**WEST SUSSEX COUNTY COUNCIL
PLANNING SERVICES CONSULTATION**

SUBJECT: AL/51/17/PL - 1 No. dwelling.

Woodgate Farm, Westergate Street, Aldingbourne, PO20 3SS

Client	Bryan Fry
Drawing Title	Surface Water Drainage

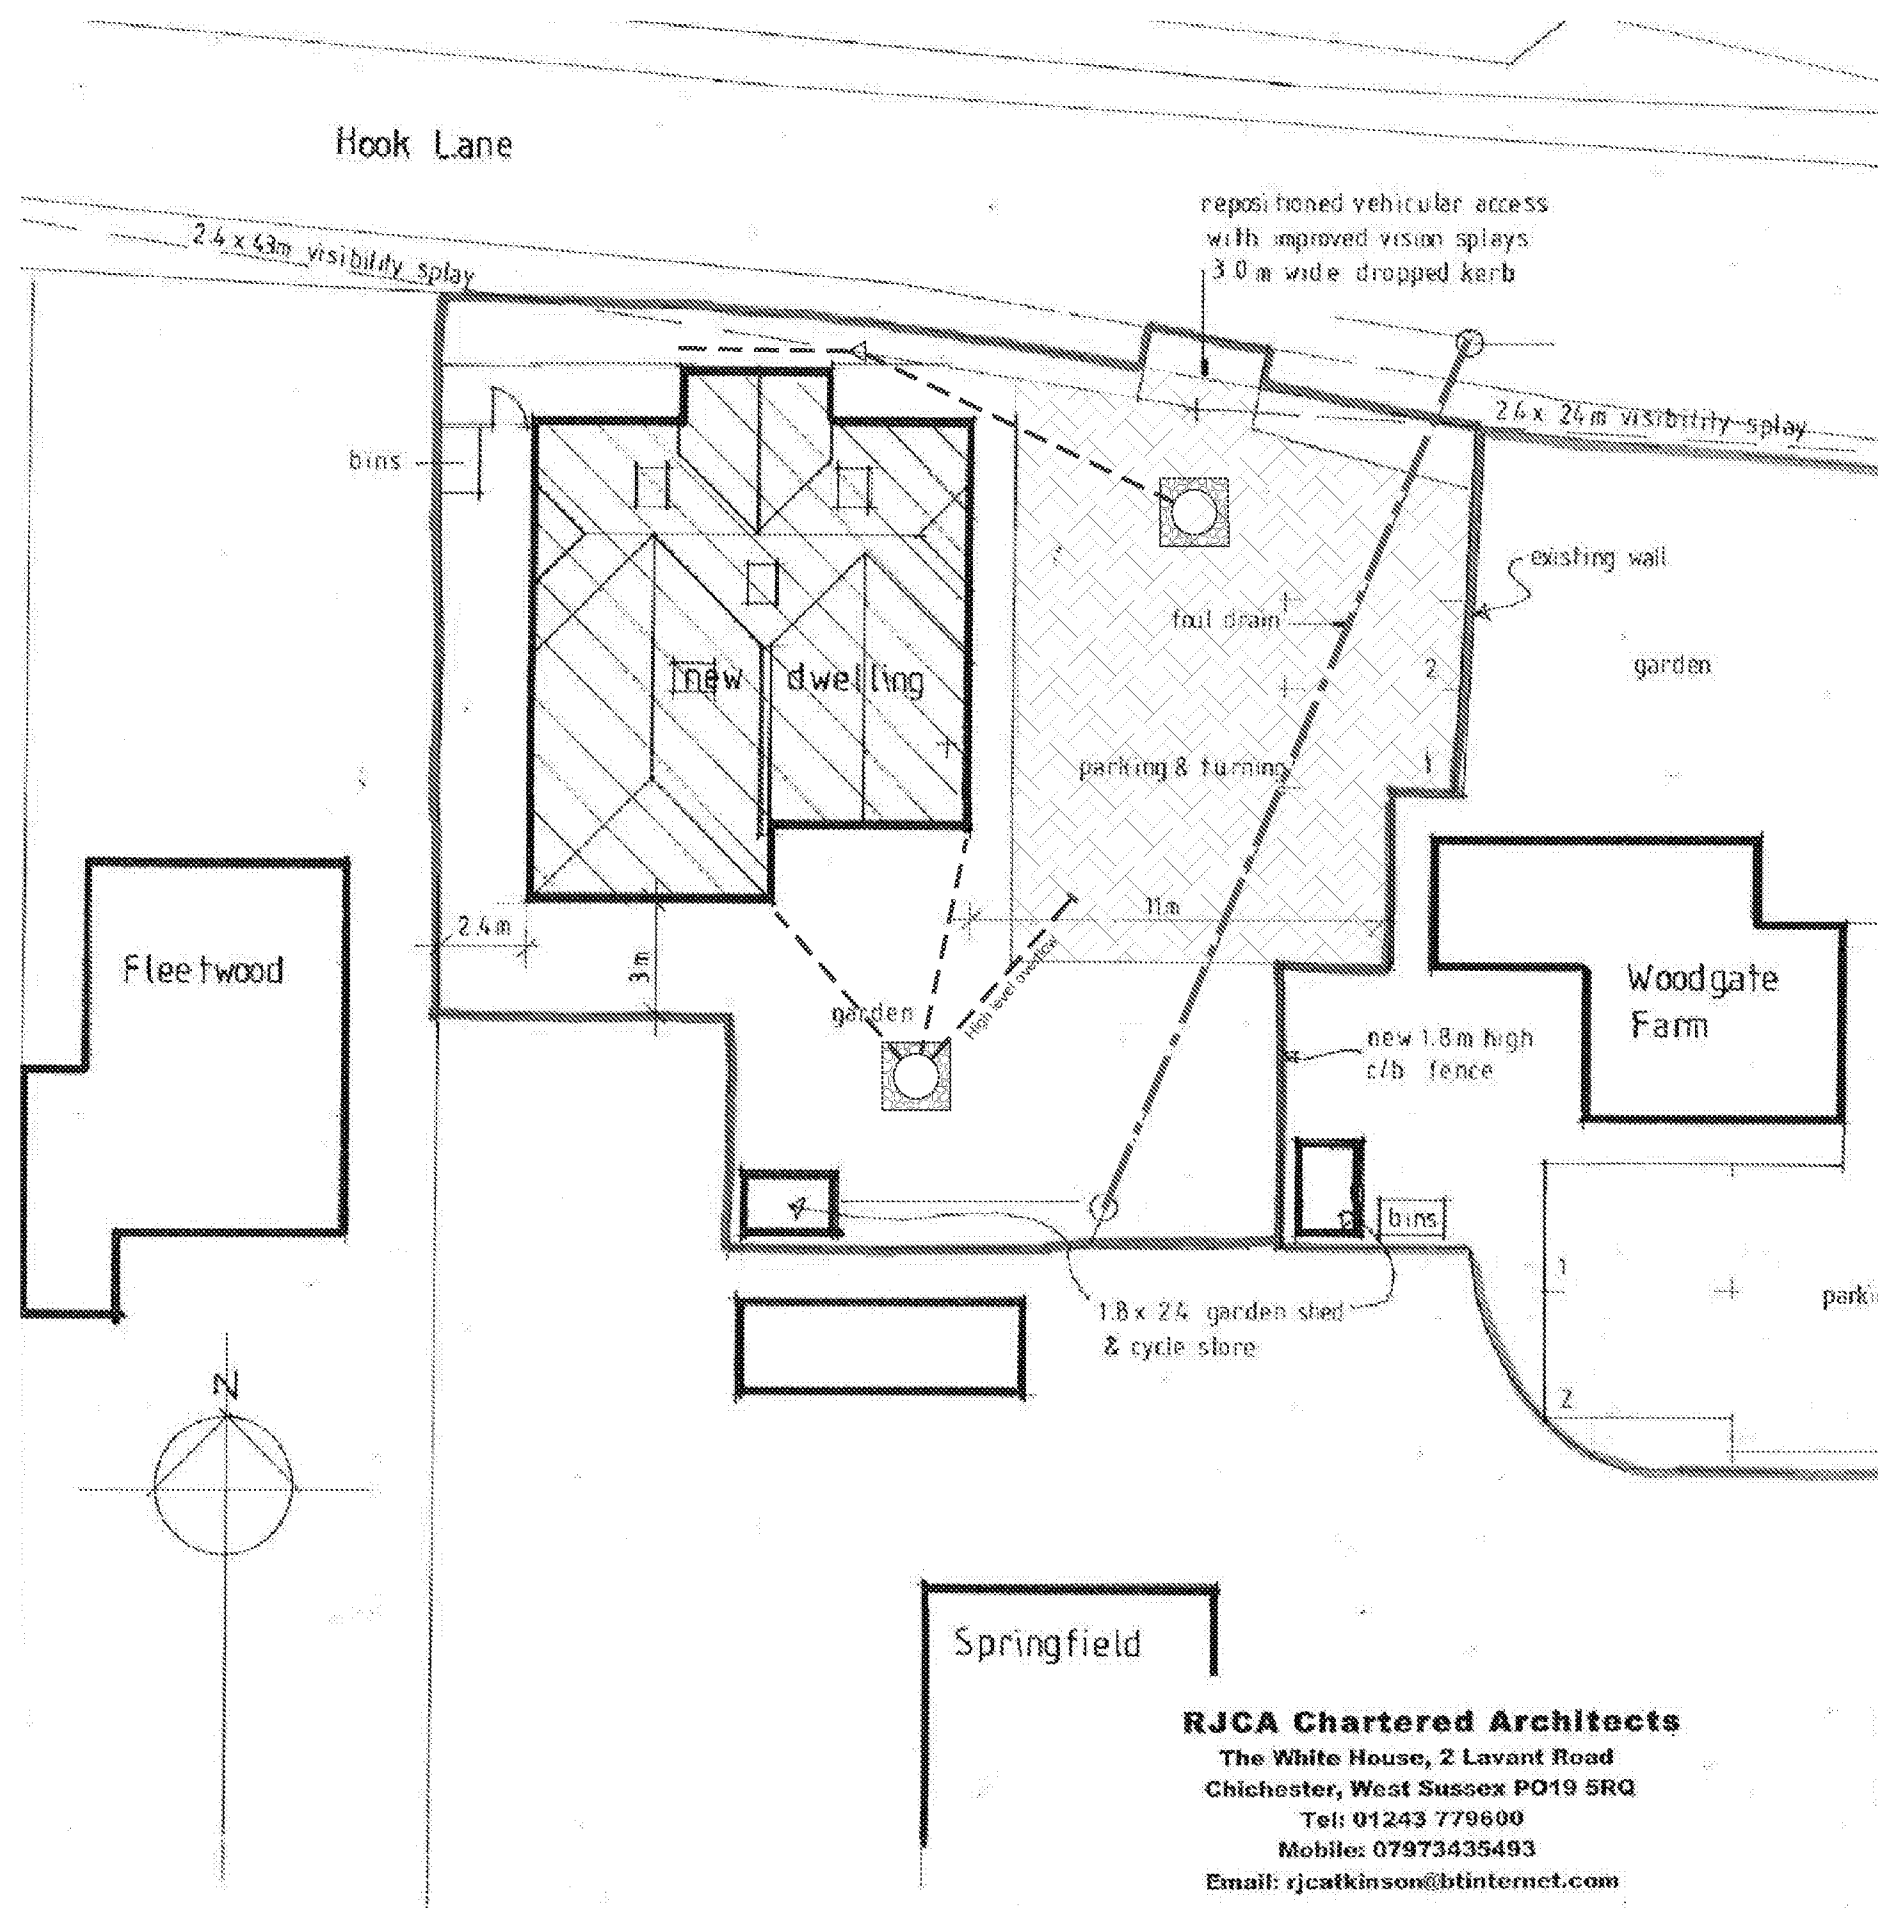
A study of the plans and Design and Access Statement demonstrates that off-street parking for two vehicles will be provided as part of this proposal. This is sufficient for a dwelling of this size. A turning space is also included to allow vehicles to exit onto the carriageway in a forward gear.

The vehicle hardstanding is to be constructed using concrete block permeable paving. This is in accordance with WSCC guidance which advises against the use of gravel/shingle due to the potential for overspill onto the public highway.

The new access must be implemented under licence to a specification obtained from WSCC Highways.

No part of the development shall be first occupied until such time as the vehicular access serving the development has been constructed in accordance with the approved drawing.

No part of the development shall be first occupied until the vehicle parking and turning spaces have been constructed in accordance with the approved plan. These spaces shall thereafter be retained for their designated use.
